December 19, 2025

Re: Lobo Plaza TIS – Review Comments

Per your request, Lee Engineering has reviewed the “Lobo Plaza TIS Report” dated September 22, 2025, as authored by Terry Brown and Ronald Bohannon of Tierra West, LLC.

SITE PLAN - DFT

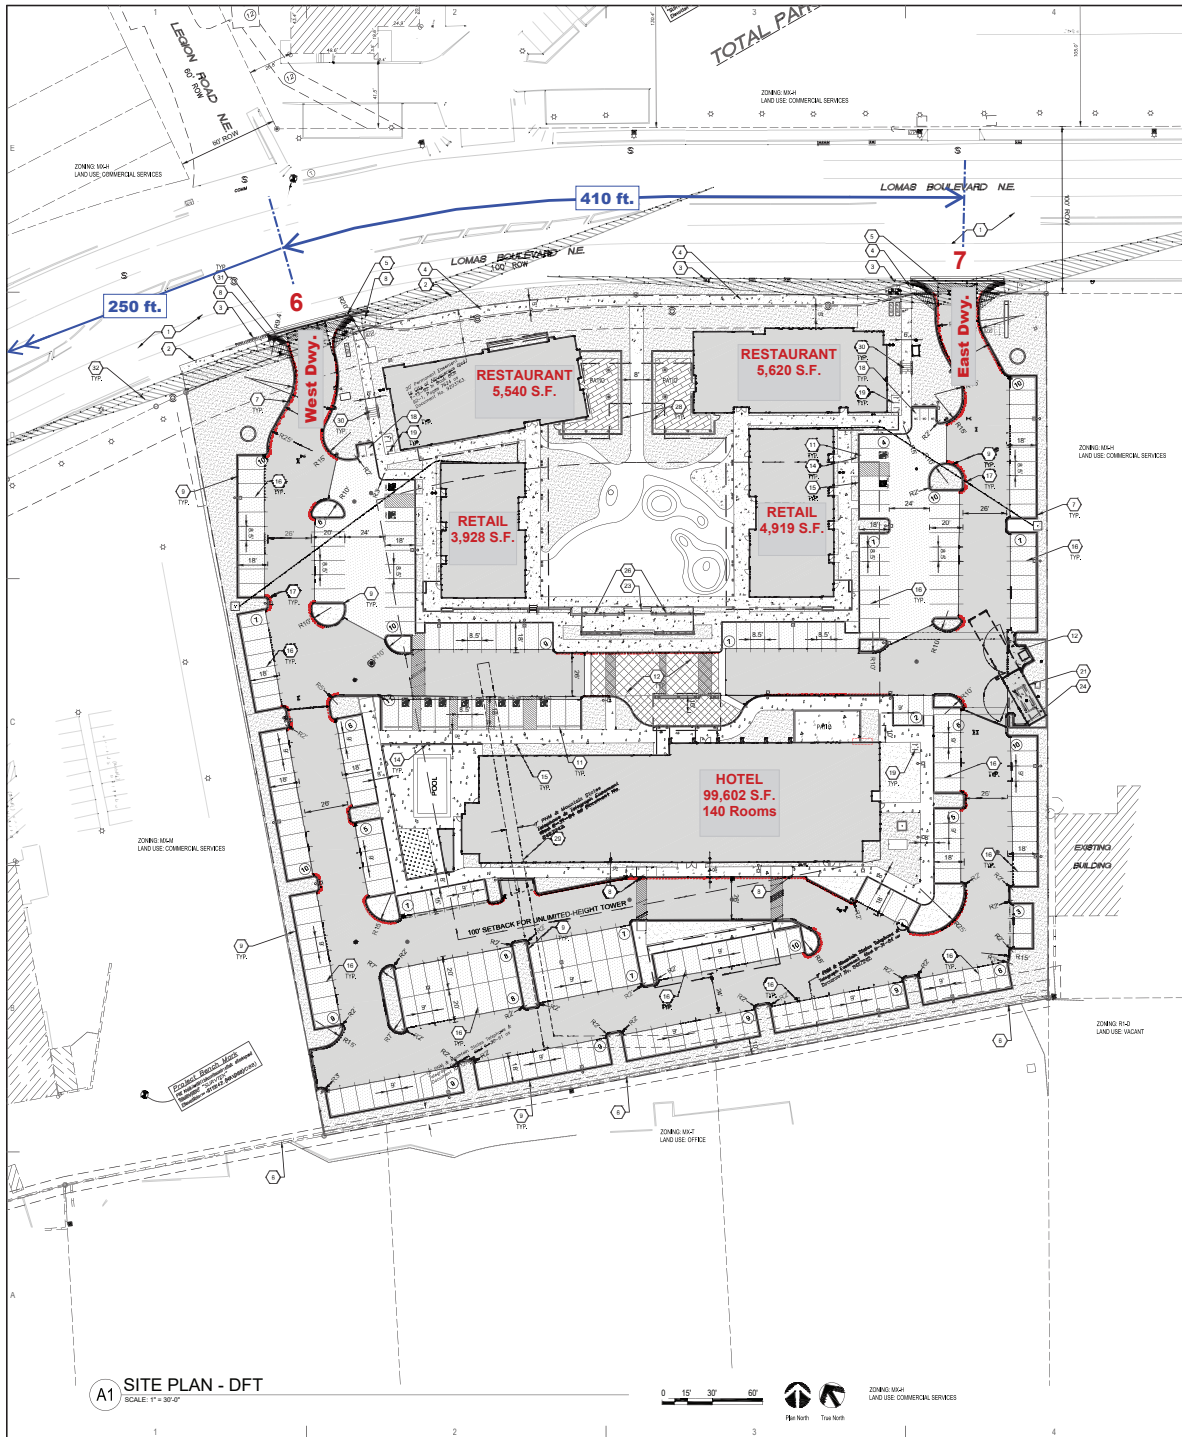
- Existing driveway located at an existing median break location. Stop-controlled NB approach indicates LOS C/D. Analysis indicates all E/W volumes in platoon and outbound lefts make a 2-staged movement. Can this be accomplished in a 16' median width?
- Driveway, although existing (abandoned), has only a 240-foot separation with Torq driveway.
- Right-turn deceleration lane analysis not performed. Need on a 6-lane facility?

- Driveway located at an existing median break location. Stop-controlled NB approach indicates LOS C/D. Analysis indicates all E/W volumes in platoon and outbound lefts make a 2-staged movement. Can this be accomplished in a 16' median width?
- Driveway, although existing (abandoned), has a 360-foot separation with the west driveway and existing UNM parking lot driveway. Minimum SAMM driveway spacing on an UPA roadway is 402 feet (Table 18.C-1).
- Right-turn deceleration lane analysis not performed. Need on a 6-lane facility?

Page 32, The analysis of the site driveways used a 2-stage left-turn movement. With the median opening only 16 feet wide, should the analysis be conducted without staged movements? Drivers may perform more complex routing maneuvers if left turns from driveways operate with high delays. By allowing two stage left turns, is there a safety issue due to limited width and potential back of vehicle extending into opposing through lane?

Page 33, Capacity Analysis, West Driveway. Analysis indicates all volumes in platoon. NB approach indicates outbound movements at LOS C/D. Can NBL make staged movement with a median width of 16 feet?

Page 36, Capacity Analysis, East Driveway. Analysis indicates all volumes in platoon. NB approach indicates outbound movements at LOS C/D. Can NBL make staged movement with a median width of 16 feet?

- Intersection #2. No mention of EBL queue extending beyond turn bay, impacts/mitigation.
- Intersection #2. No mention of WBR queue extending beyond turn bay, impacts/mitigation.
- Intersection #3. No mention of EBL, WBL, and NBL queue extending beyond turn bay, impacts/mitigation.
- Intersections #6 and #7. Mitigation should also include fixing any damaged curb, maintaining sidewalks and ramps to be ADA compliant.

- Stripe second EBL turn lane at Intersection #2. Review AASHTO Case F Intersection Sight Distance to determine movement control (protected-permissive vs protected) as WBL turn at intersection #4 may affect sight distance for EBL turns at Intersection #2.
 - Note: development does not contribute trips to this movement and condition is present under 2028 NO BUILD scenario. Could not verify if issues are present under existing conditions.
- Extend WBR deceleration lane at Intersection #2 per SAMM criteria.

- Note: development contributes 2 AM and 2 PM vehicles to this movement.
- Although COA jurisdiction, COA may require extensions to turn lanes at Intersection #3.
- Construct ADA curb ramps at Intersection #6 & Intersection #7, replacing damaged curb and gutter.
